Your Ref 23/01151/APP

6th November 2023

PROPOSED NON-MATERIAL AMENDMENT TO PLANNING PERMISSION REF. 23/01151/APP AT HMP SPRINGHILL, EDGOTT, AYLESBURY

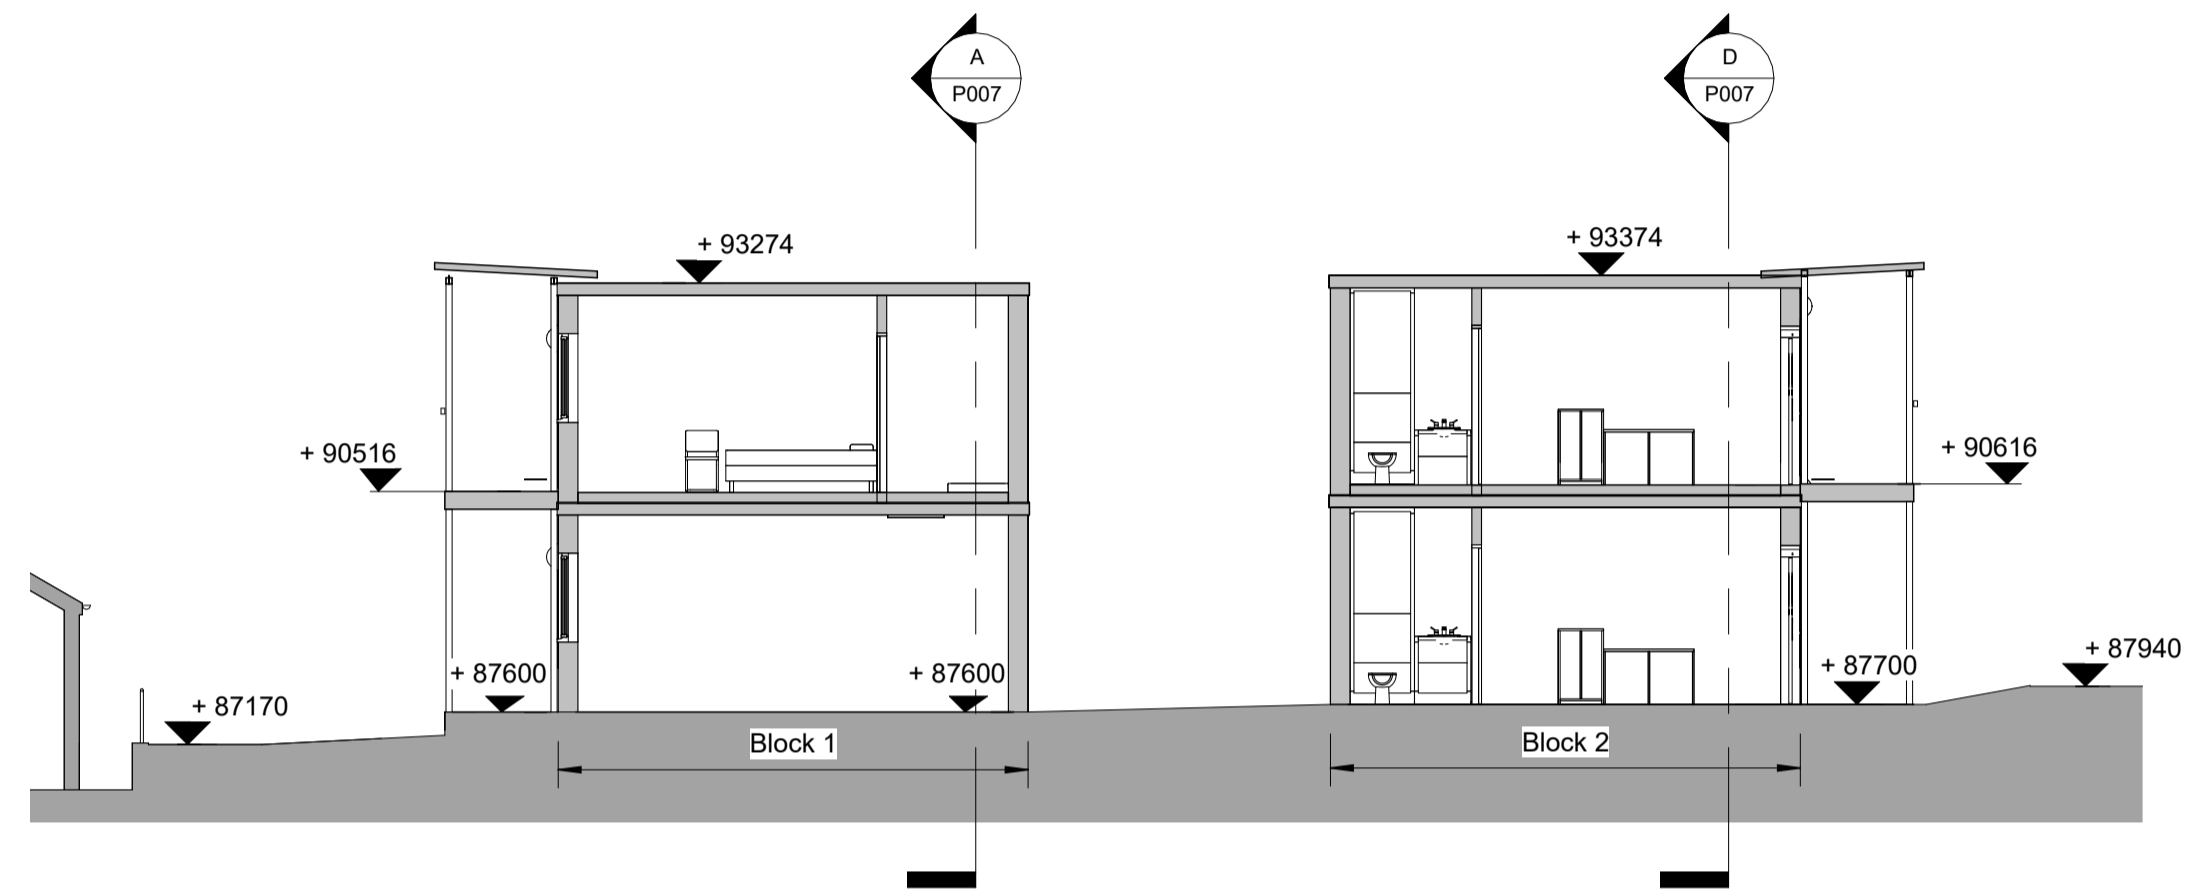
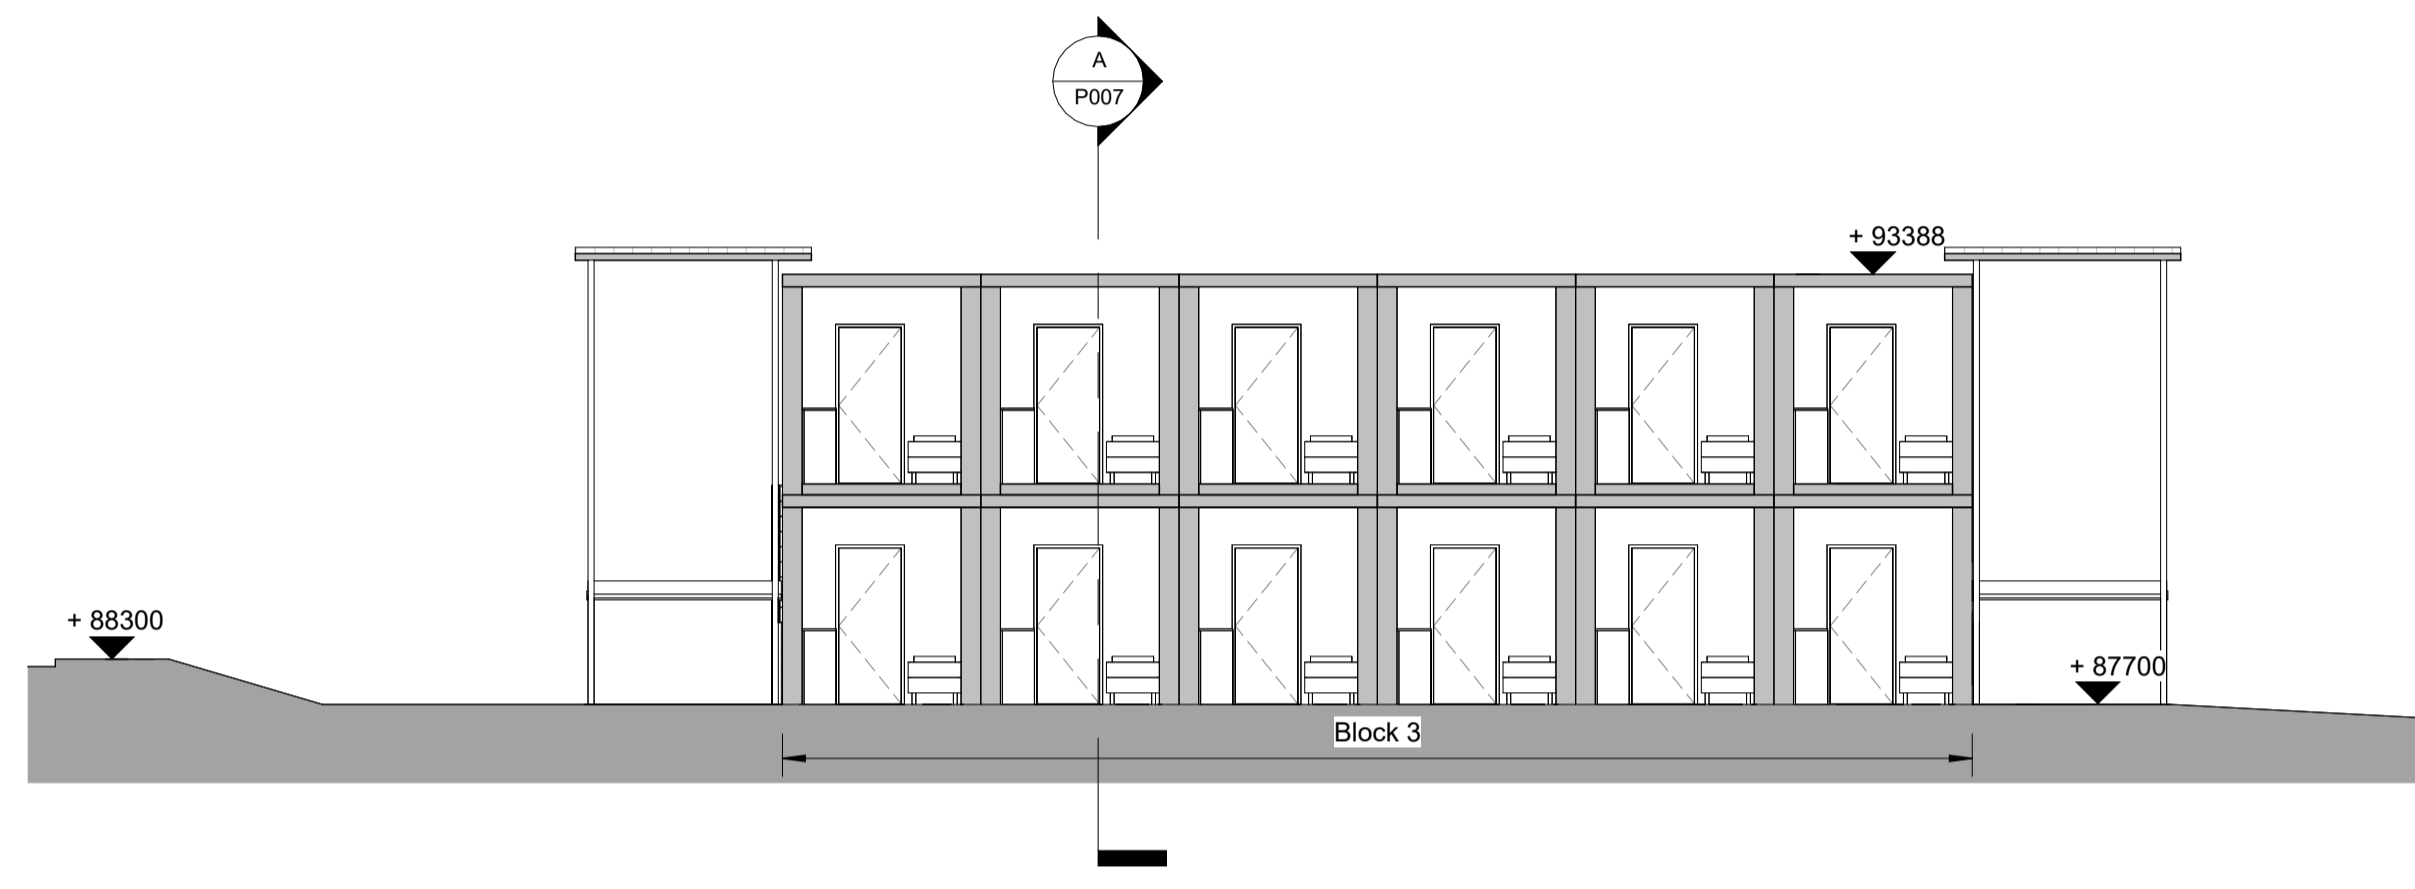
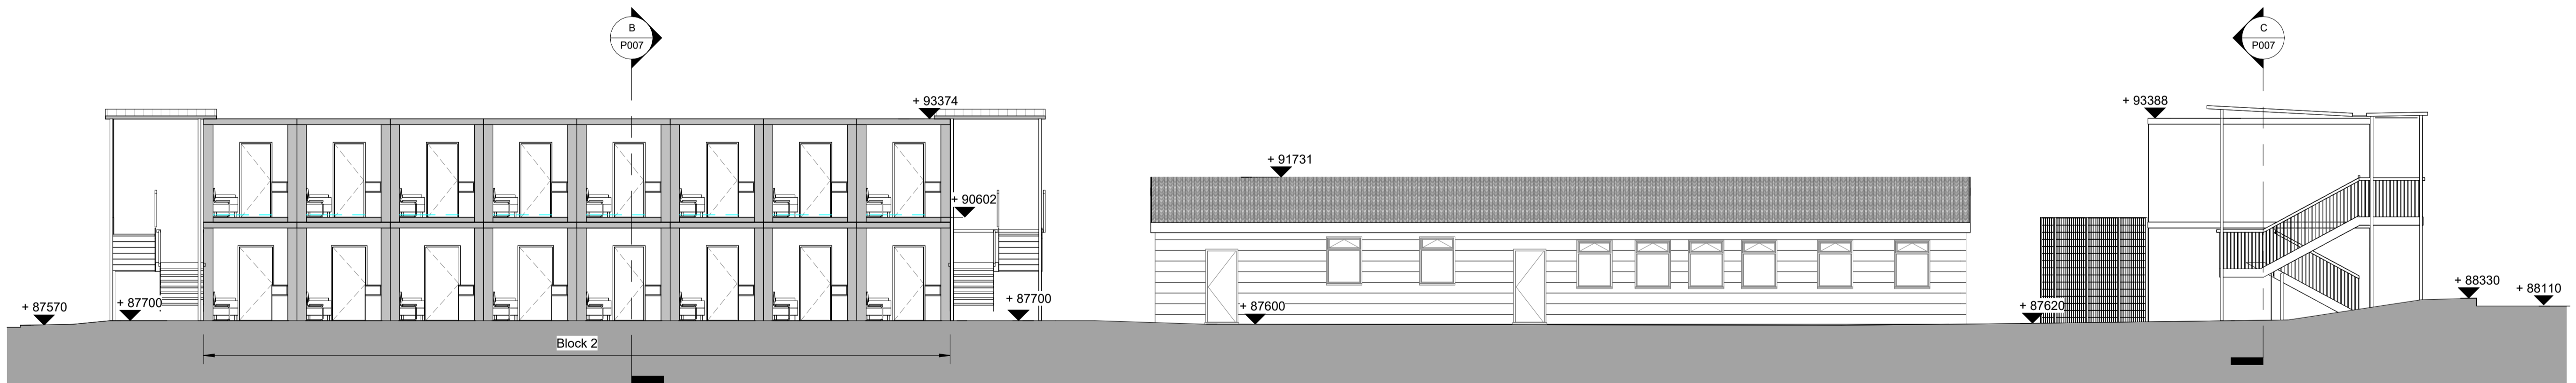
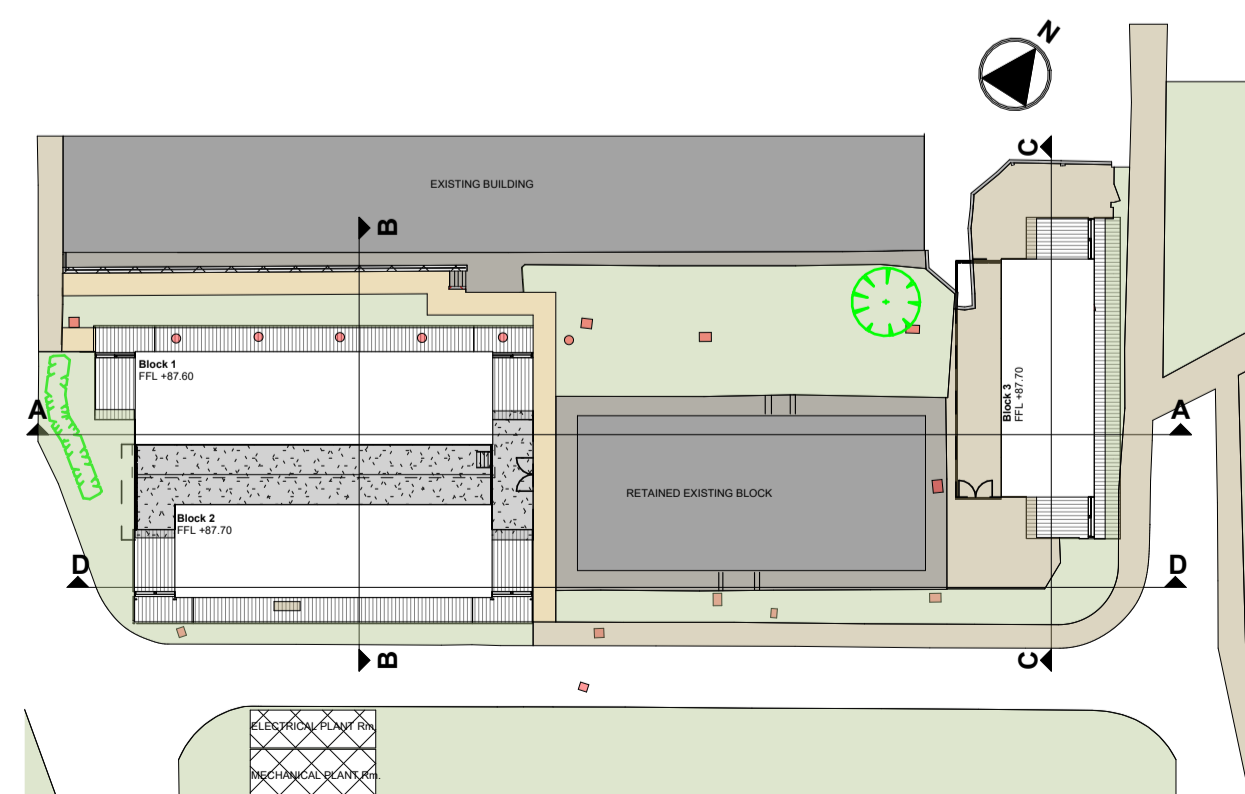
The finished floor levels of blocks 1 & 2 have been raised meaning the ridge is higher in comparison to the original. A step in the level has been removed as a result.

Block 3 has been moved to the east by 2 meters.

Site Sections – Rev C (ref: 441830-HLN-ZZ-DR-A-P007)
